RE: 1 , EAST ONSLOW CLOSE , FERRING . APP FG/27/15/HH

FLOOR PLAN.

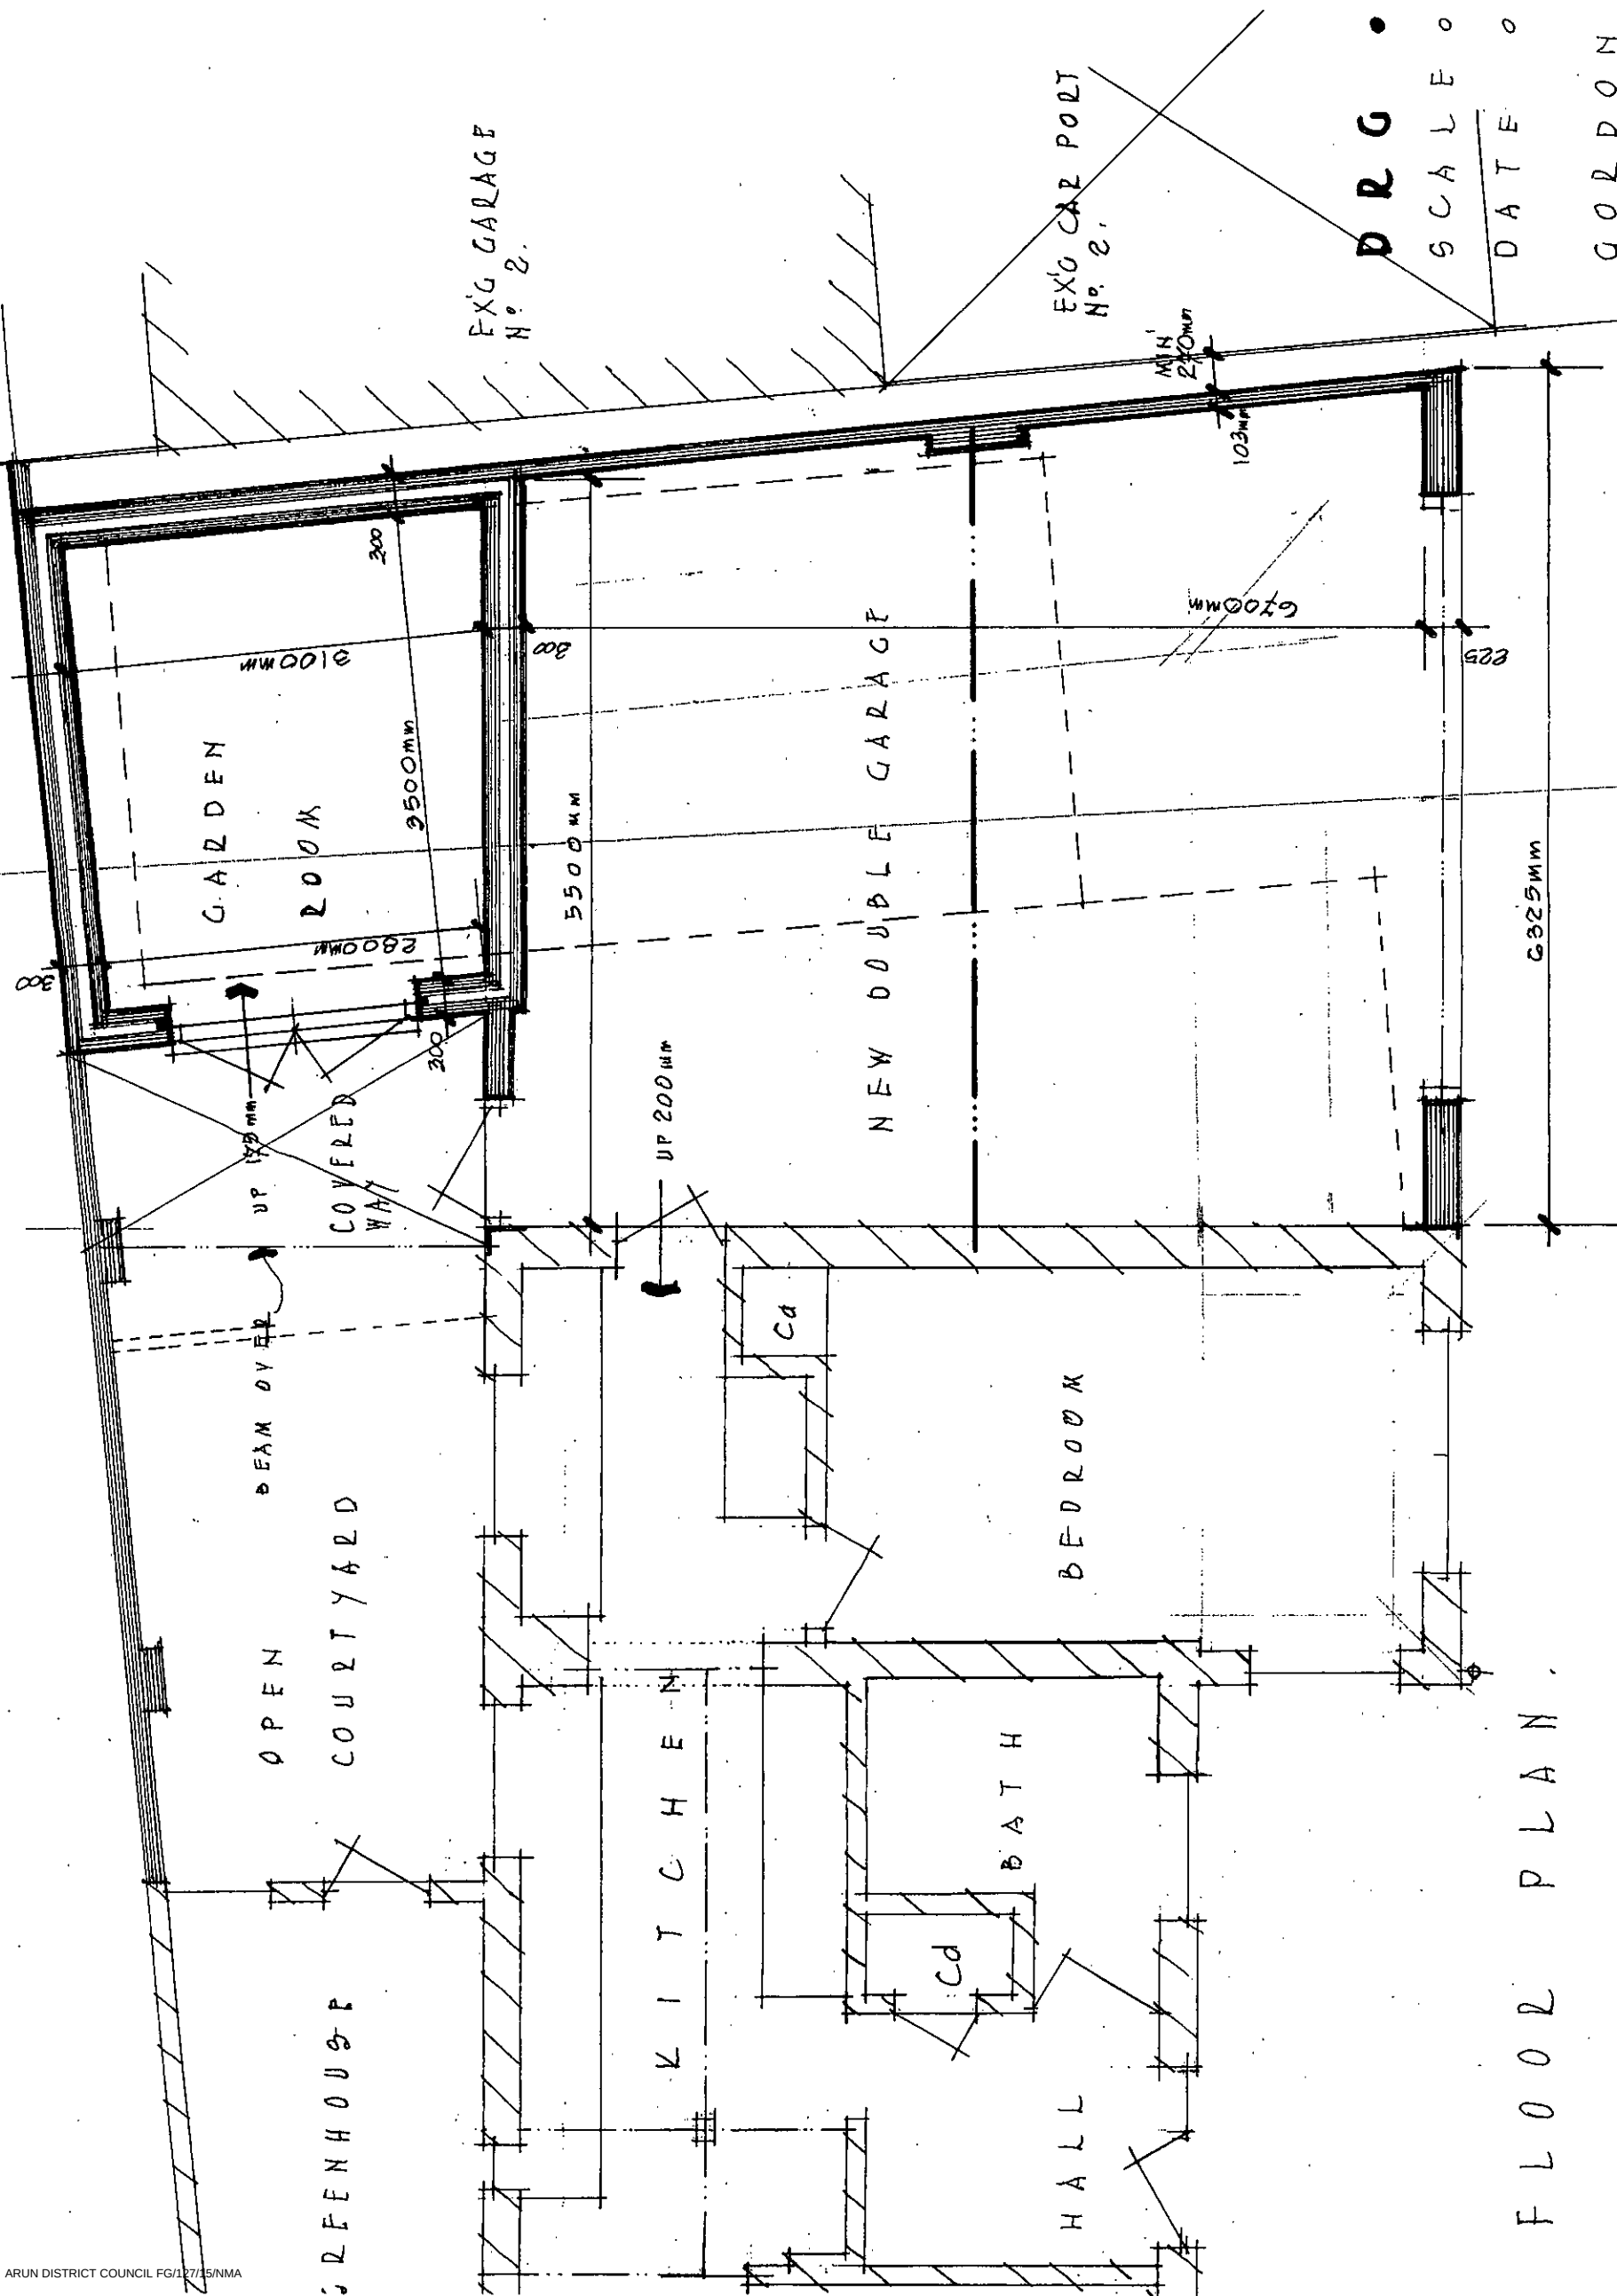
As you will see the North and West boundaries are not set at 90 degrees and the frontage is slightly wider .

The approved plans showed the North wall of the new structure to be on the boundary line , this can not happen as the eaves soffit and gutter would then overhang the boundary .

The West wall was shown to be formed immediately against an existing garden wall on this boundary , again this is not possible , plus this wall is not entirely sound and could probably fall over during progress of works . It has been put to the adjoining owner Mrs J Sheppard who is over 90 years of age , [is a good friend of the applicant [Mrs Stratton] , owner of the application site . Mrs Sheppard has agreed that the garden wall be removed and the new wall to the extension plus a new boundary wall be built , to ensure that she does not have any problems with this in the future .

The above are the only minor changes , the overall scheme does not change in principal , just the angles of the outer walls are varied .
